**North Carolina Department of Transportation
PROJECT ENVIRONMENTAL CONSULTATION FORM
T.I.P. No. U-3338B**

- A. Consultation Phase:** Right-of-Way
- B. Project Description:** Widening of SR 1175 (Kerr Avenue) from Randall Parkway to SR 2649 (Martin Luther King, Jr. Parkway) Wilmington, New Hanover County, NC
- C. Federal Project No.:** STP-1175(B)
WBS Number: 34932
- D. Document Type:** Categorical Exclusion Addendum 3-28-2011
Date

Figure No.
2

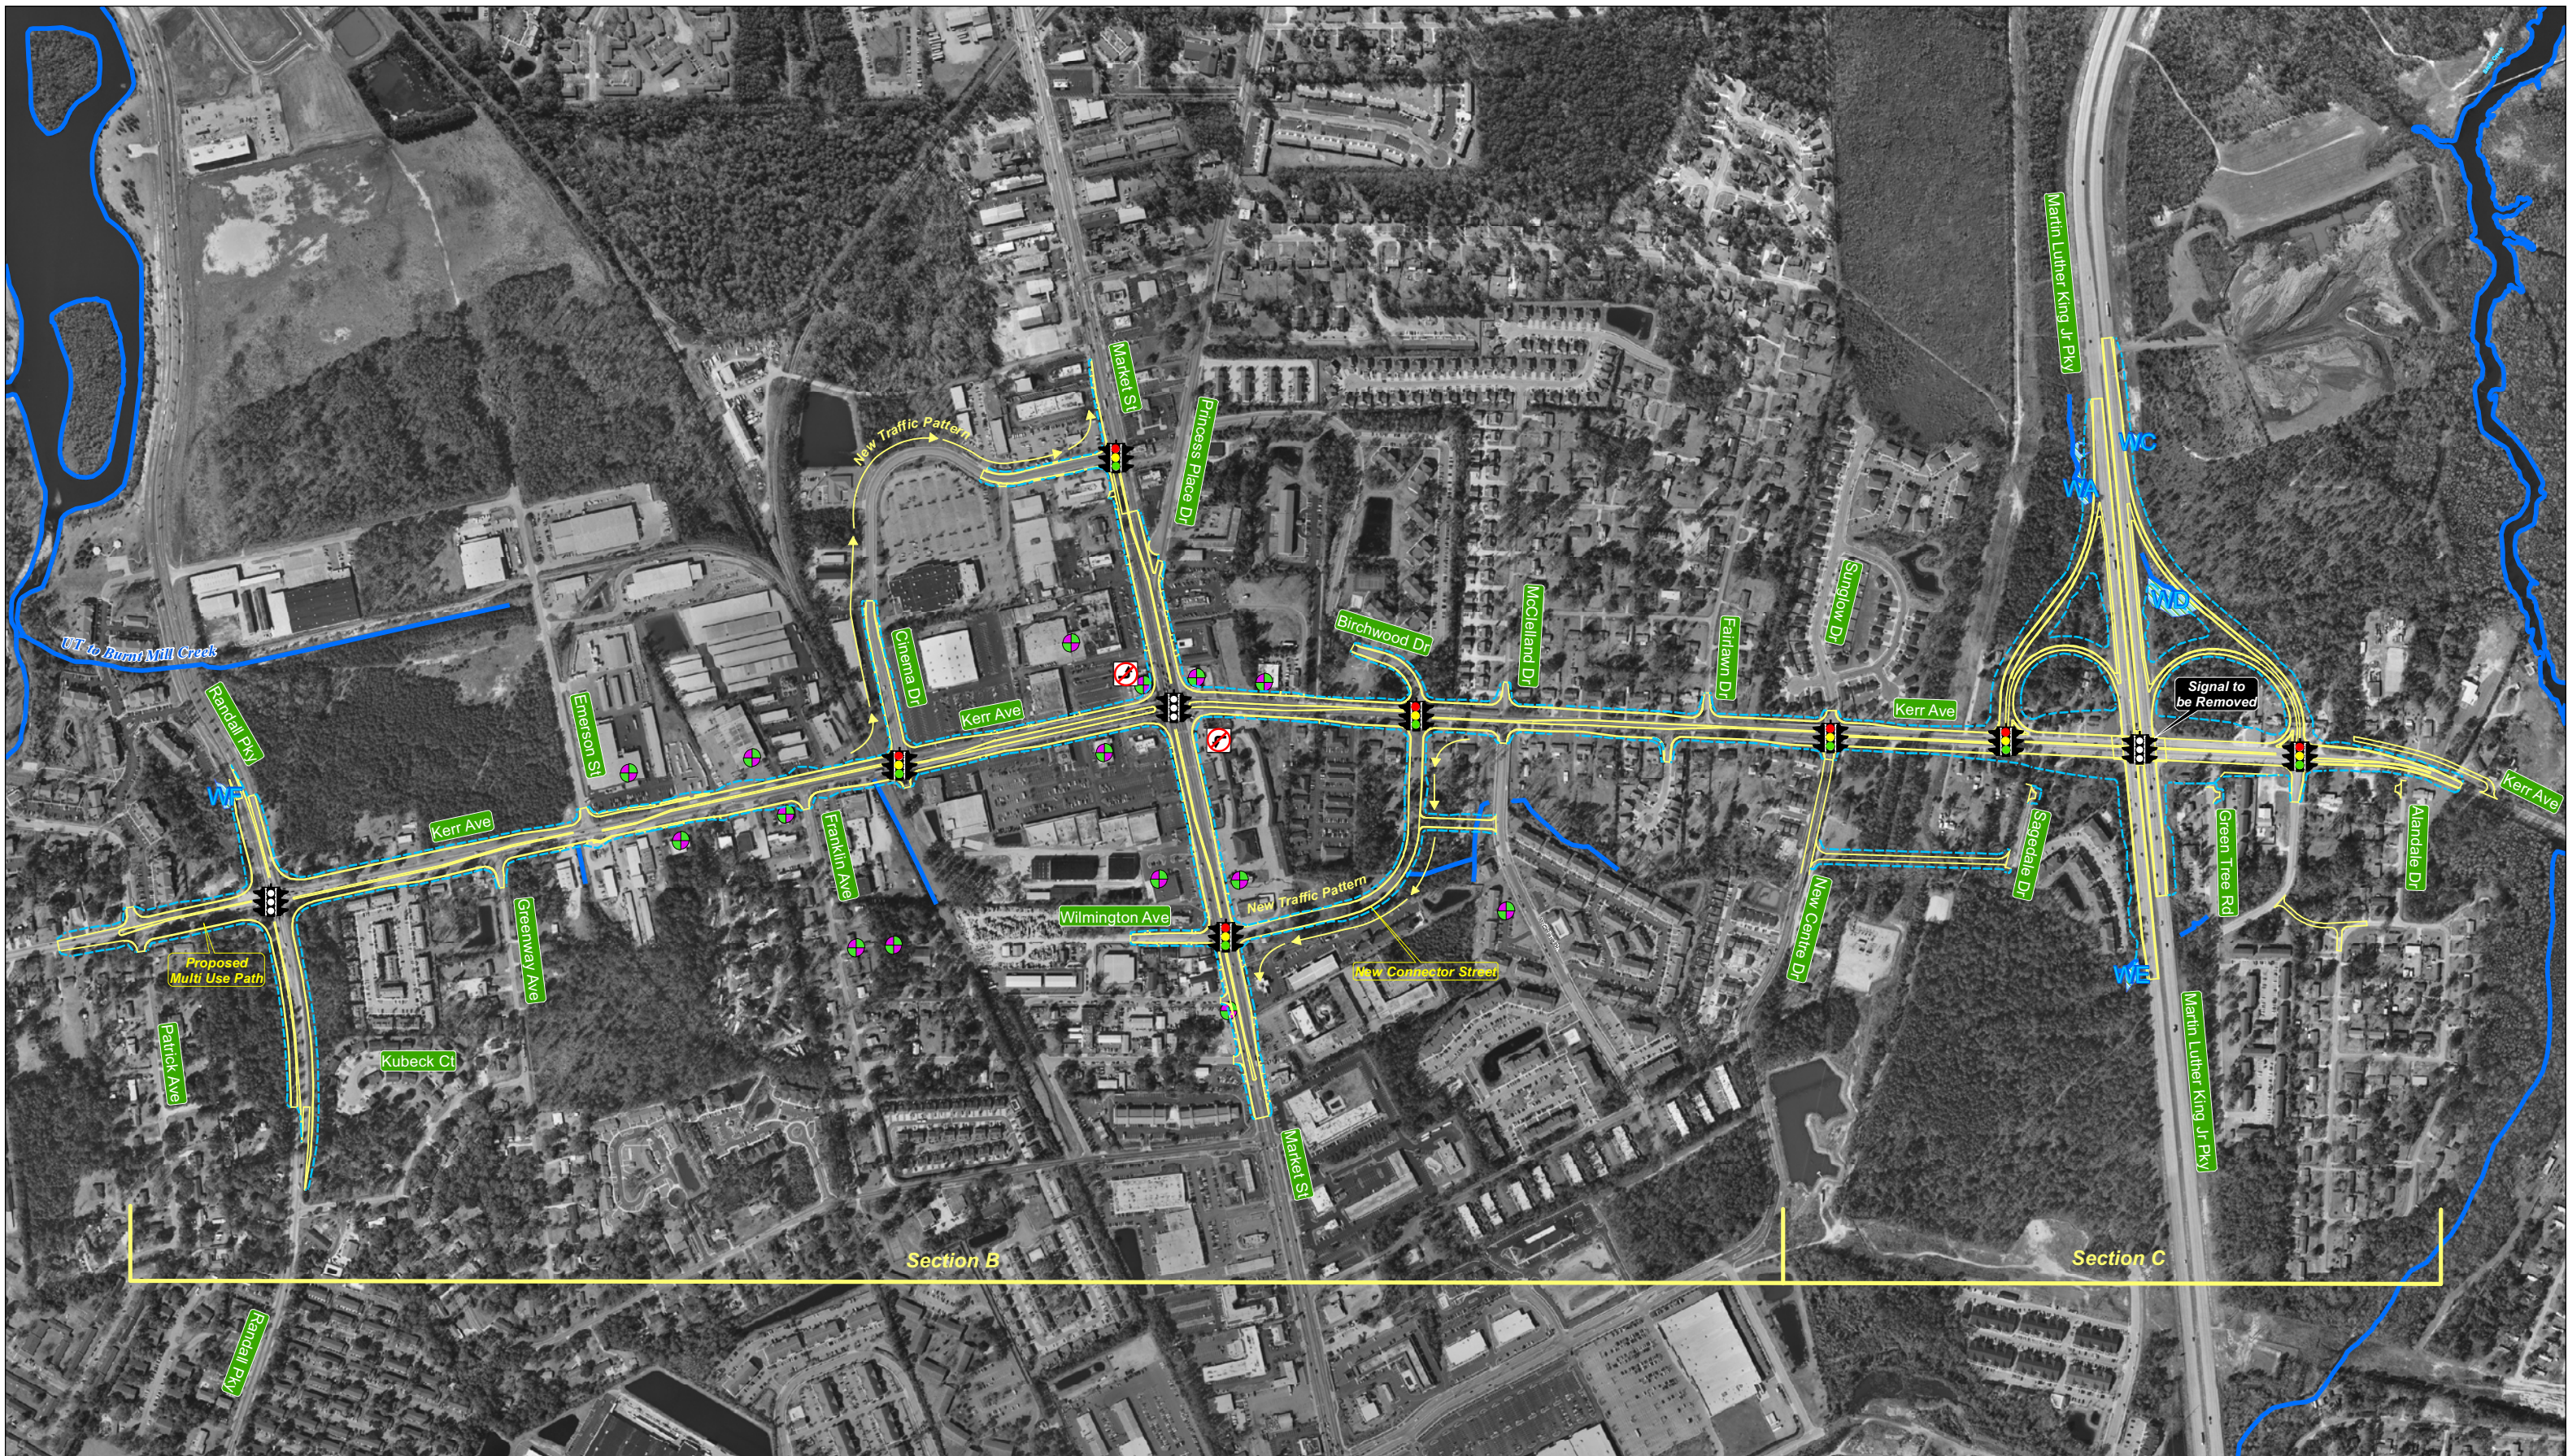
Exhibit 1 is attached, which uses Figure 2 from the CE Addendum as a backdrop to indicate where changes in jurisdictional impacts occur.

1. A small wetland exists on Randall Parkway, just west of Kerr Avenue. This wetland was not originally impacted at the time the CE Addendum was prepared; however slope stakes now indicate an impact of 0.01 acre.
2. A new connector road is proposed to the east of Kerr Avenue, which connects New Centre Drive and Sagedale Drive. The CE Addendum reported no jurisdictional resources in this location; however a recent field determination has identified a wetland in this location, as well as an associated stream. Impacts from the new connector road will result in 0.04 acre of wetland impact; however no stream impacts will occur.

1. In the area of the proposed quadrant intersection, several ditches existed in the vicinity of the new location connector road that is located between McClelland Drive and the proposed extension of Birchwood Drive. These resources were labeled as stream in the CE Addendum; however a recent field determination reclassified these streams as jurisdictional streams. This change in reclassification causes a permanent impact to approximately 157 linear feet of stream.
2. At several intersecting streets along Kerr Avenue, ditches existed along the roadway and also along an abandoned CSX railroad line. A recent field determination reclassified these ditches as jurisdictional stream, which results in a total of 128 linear feet of permanent impact. The impacts occurred near Emerson Drive (45 lf), Cinema Drive (35 lf), and Birchwood Drive (48 lf).
